From: [REDACTED]
Sent: 01 January 2023 17:51
To: Planning
Subject: Re: Planning application 3/2022/1129 FAO David Kilmartin

Address of Development: Bridge Hey Wood Caravan Park Dunkirk Farm Read BB12 7RR

"Retrospective change of use with minor engineering works and associated landscaping works for the reuse of the former railway embankment and track bed to form an informal recreational amenity area in association with the adjacent holiday park"

Earth bund and bench seating
Scale 1:200

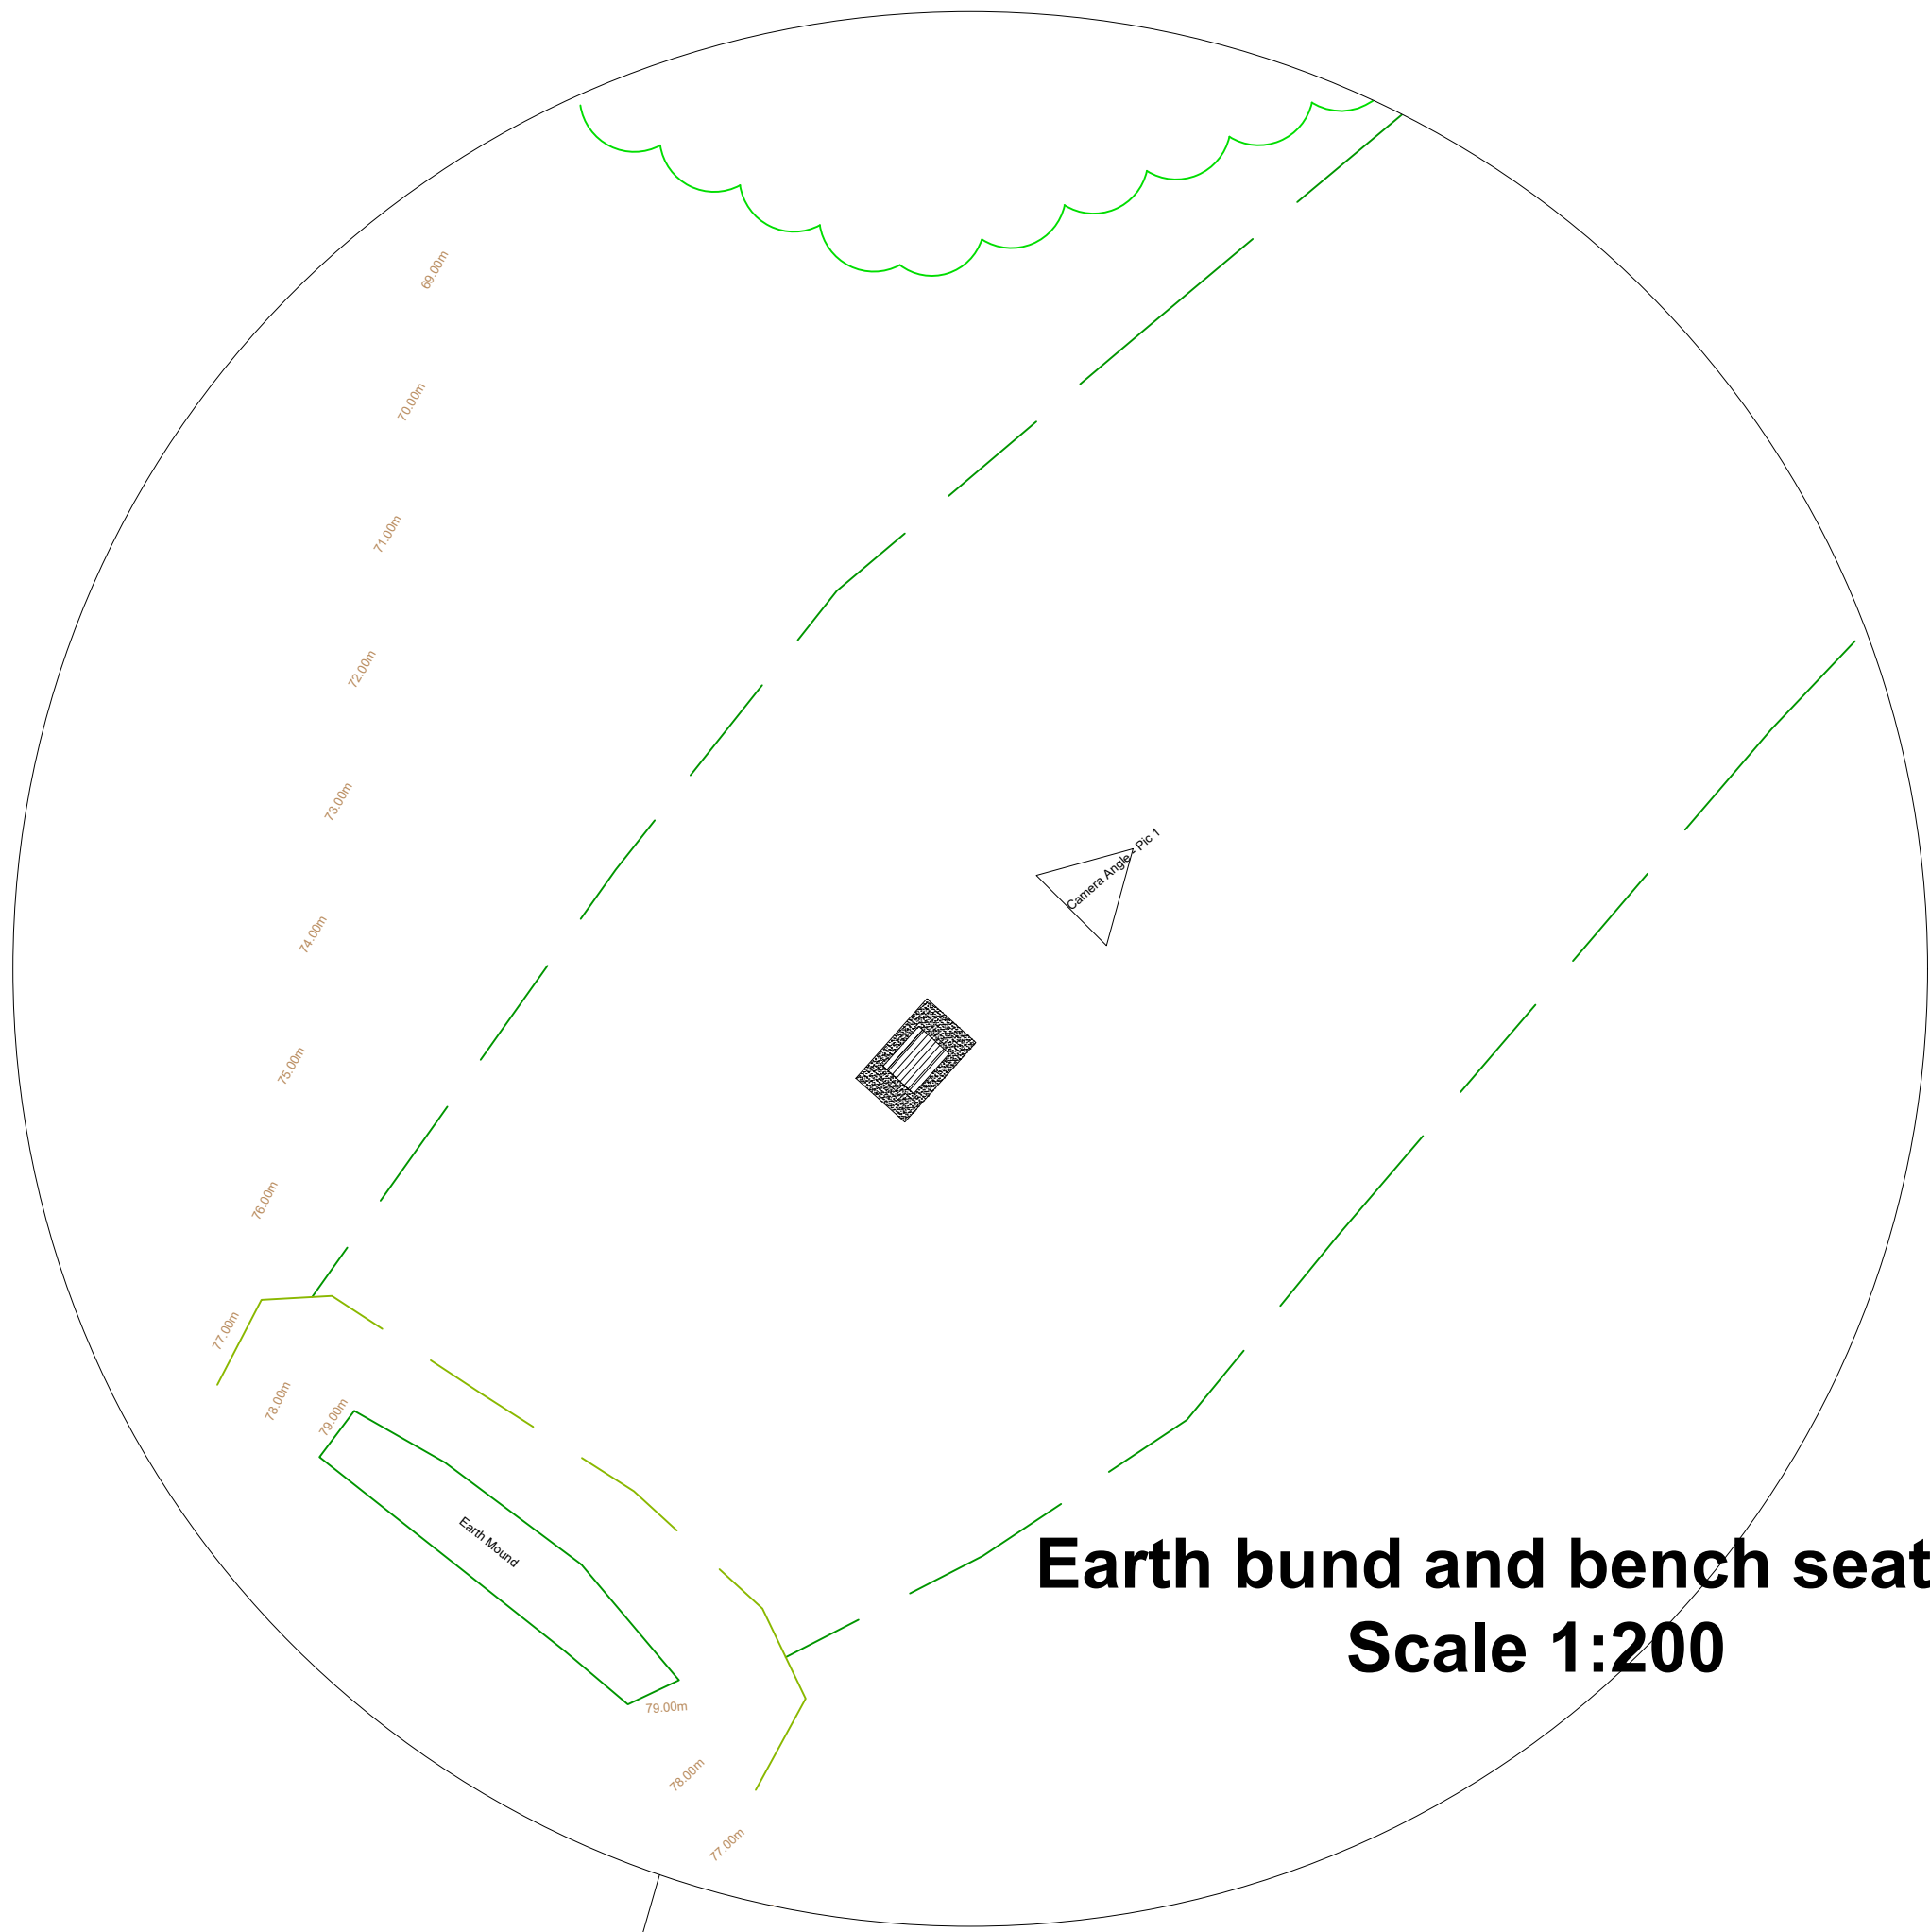
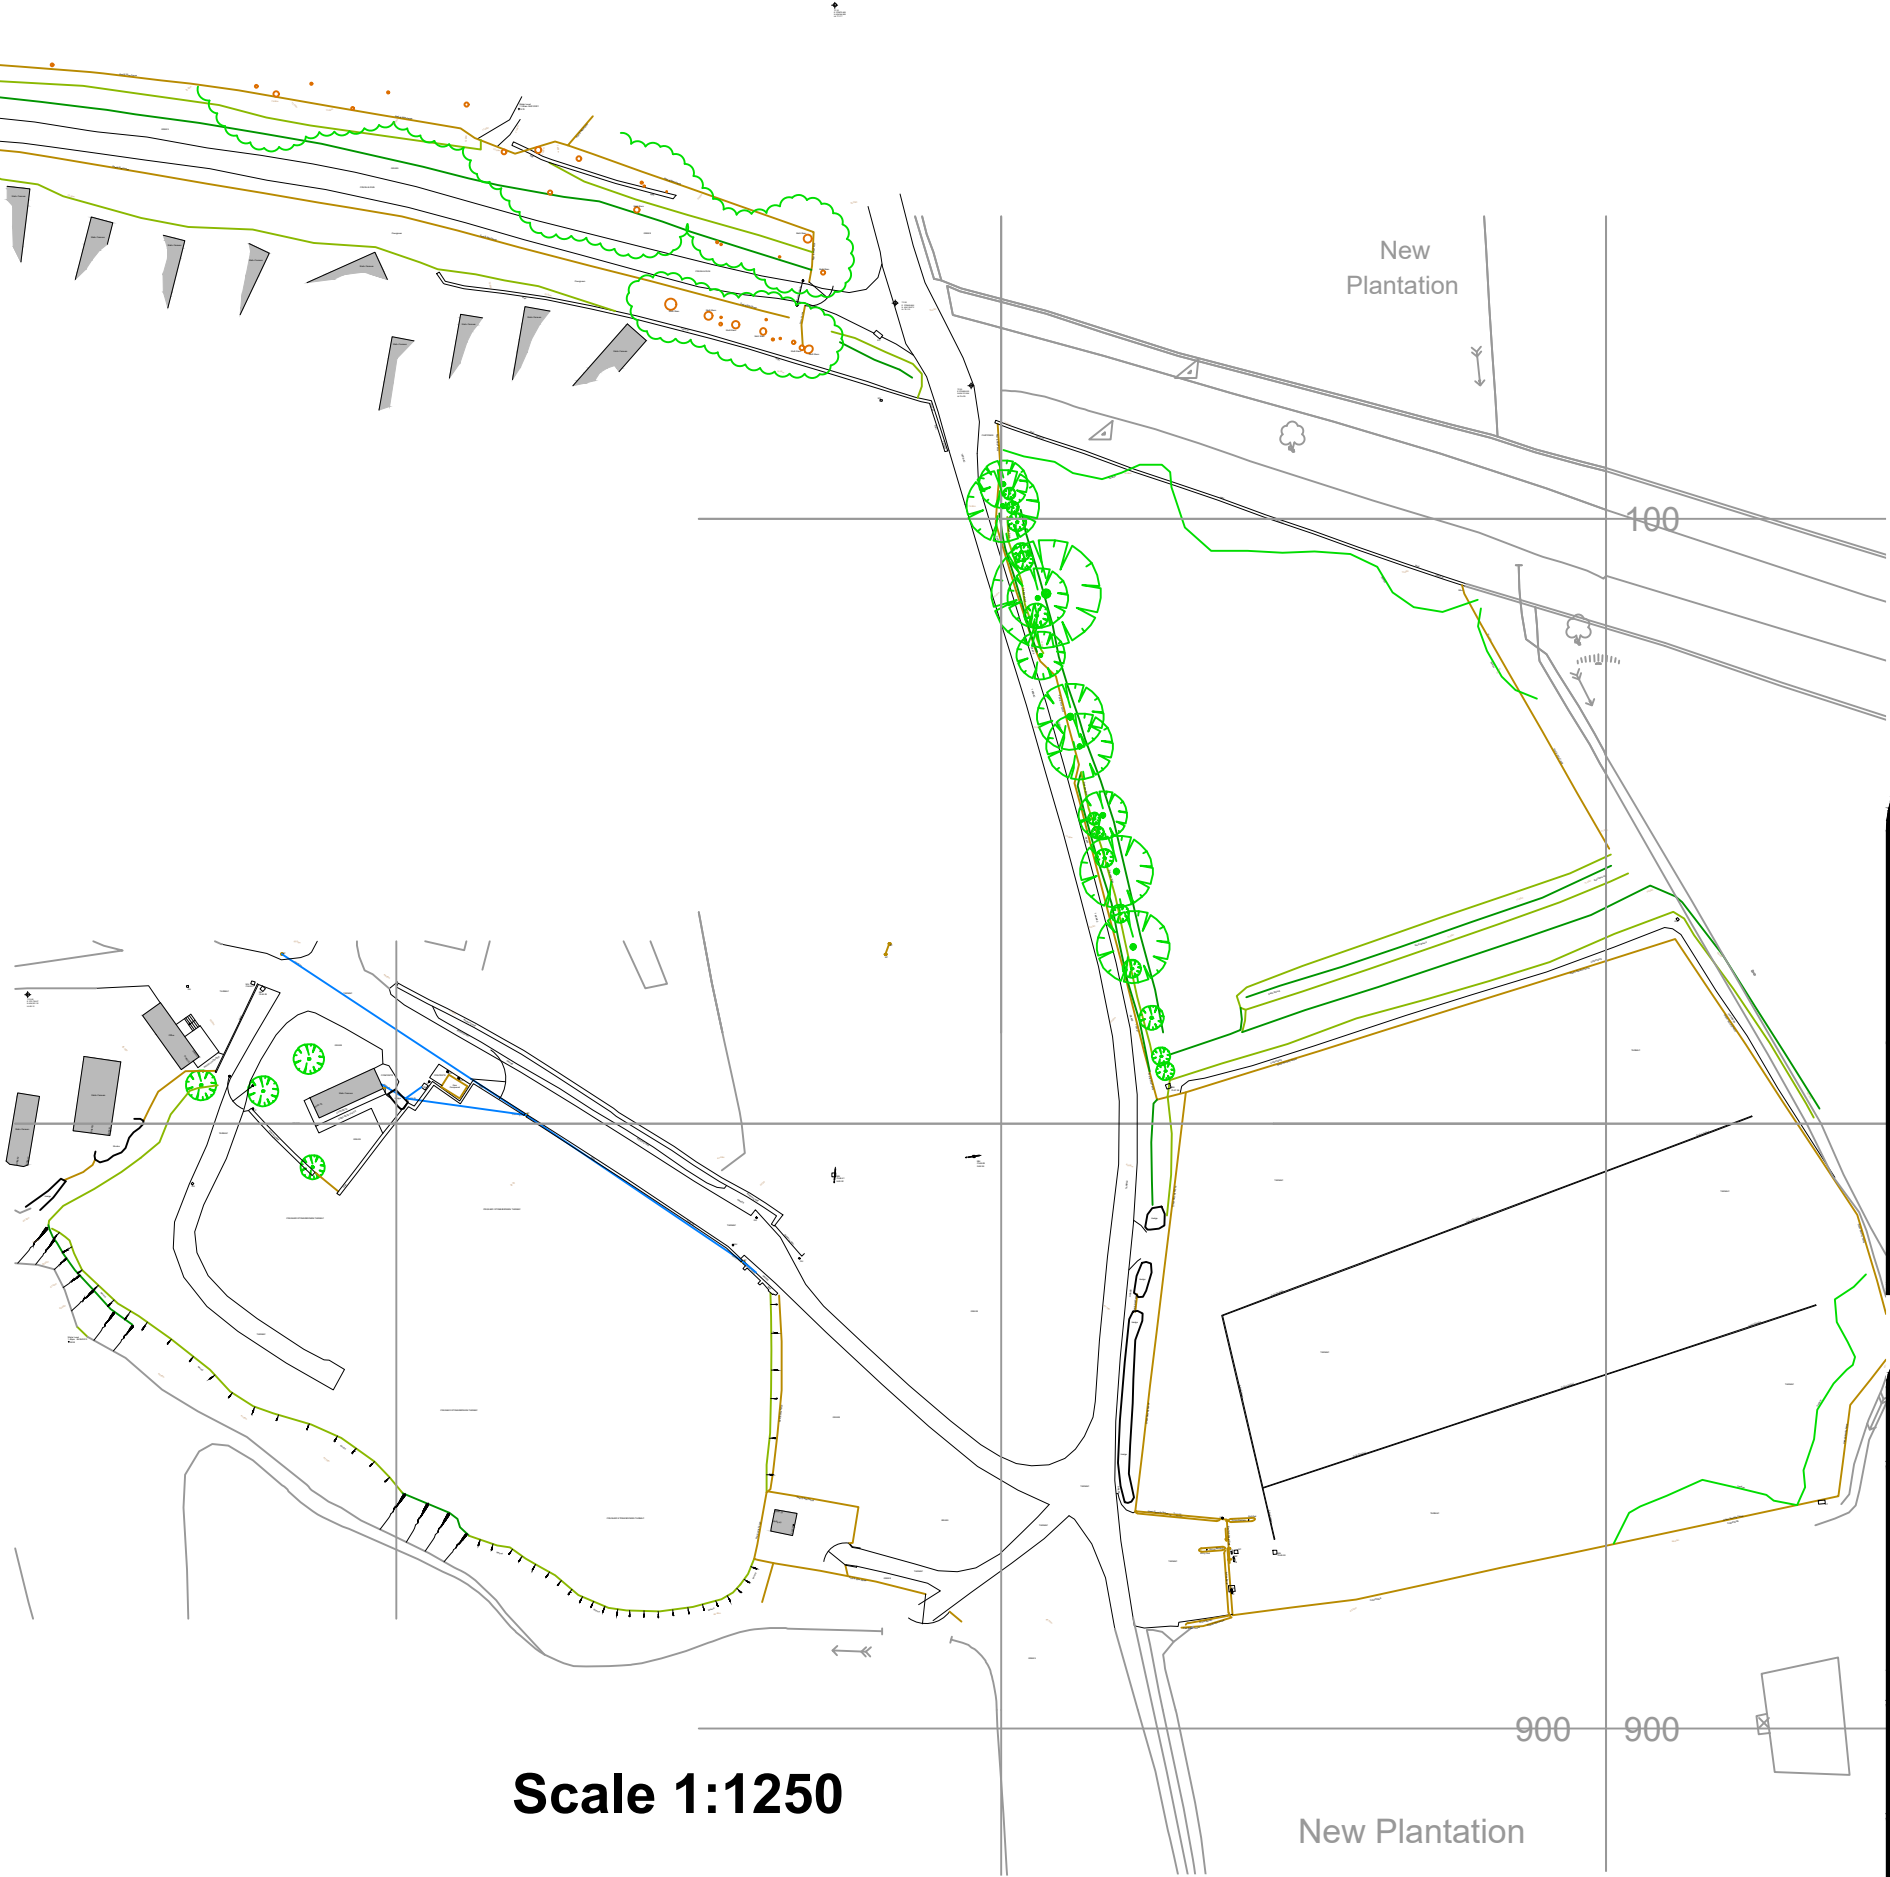
1. The bund and ditch that have been created at the Northern end of the Martholme viaduct are.

ii. The ditch has removed the earthen retaining structure to the North end of the viaduct, this could over time lead to the degradation of the structure in this area.

2. In the covering letter (see attached) the landowner states that the bund and ditch are to prevent trespass. There are already sufficient measures in place to prevent access with the 2 meter high palisade fencing and hailows at the northern end of the viaduct and the substantial drop 4 to 5 meters at either side of the viaduct wall at this point.

- 1) As a part of the alterations which have already been made, a deep trench (approximately 3 metres deep) has been cut across the railway bed abutting the stonework at the north east end of Martholme viaduct. This has exposed the stonework on the end of the bridge to erosion which it was not designed to withstand.

- 2) Additionally the railway embankment formed a buttress against the end of the bridge, a c3 metre depth of which has now been removed. I am concerned that this may destabilise the stonework at the end of the bridge.
